Replacement of 2 No. windows & 1 No. door with PVCu Heritage Flush type to rear elevation. This application affects the character & appearance of the Littlehampton Seafront Conservation Area.

Second Floor Flat 37C South Terrace Littlehampton

Thank you for your internet comments made on 29th April 2020 which has been recorded as **'an objection'** with the comments as follows:

Proposed East Elevation of Rear Outrigger - 1/100

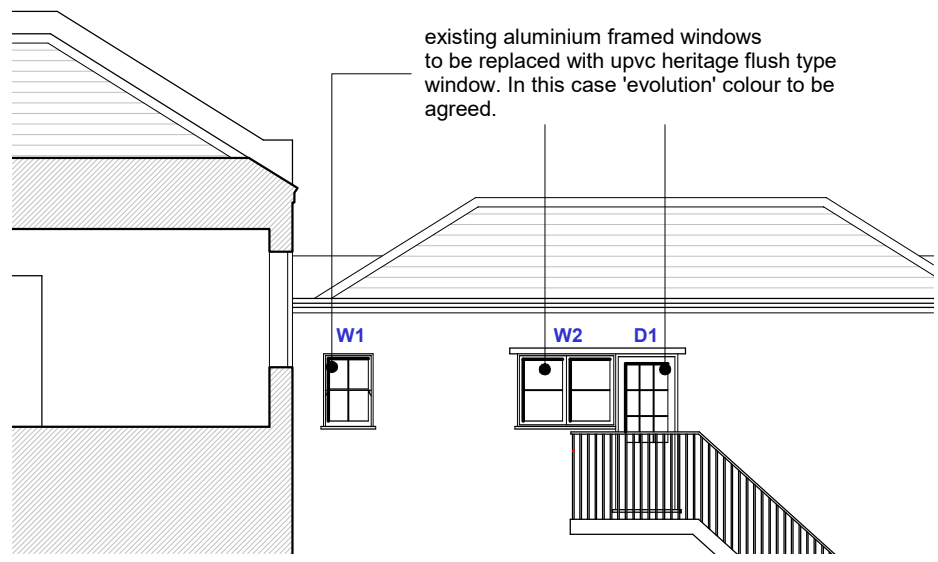
Littlehampton Town Council object on the grounds that the design and materials proposed are out character, contrary to Arun Local Plan Policy D DM1 Section 1. The site is also located within the Littlehampton Seafront Conservation Area and protected by Policy HER SP1 which states "Conservation Areas will be given the highest level of protection and should be conserved and enhanced in a manner appropriate to their significance. Development likely to prejudice any of the above, including their setting, will be refused". Policy HER DM3 also states that planning permission will only be granted within a conservation area where the use of materials acknowledges the importance of the area. The proposed use of PVCu has the potential to "erode the appearance" of these area
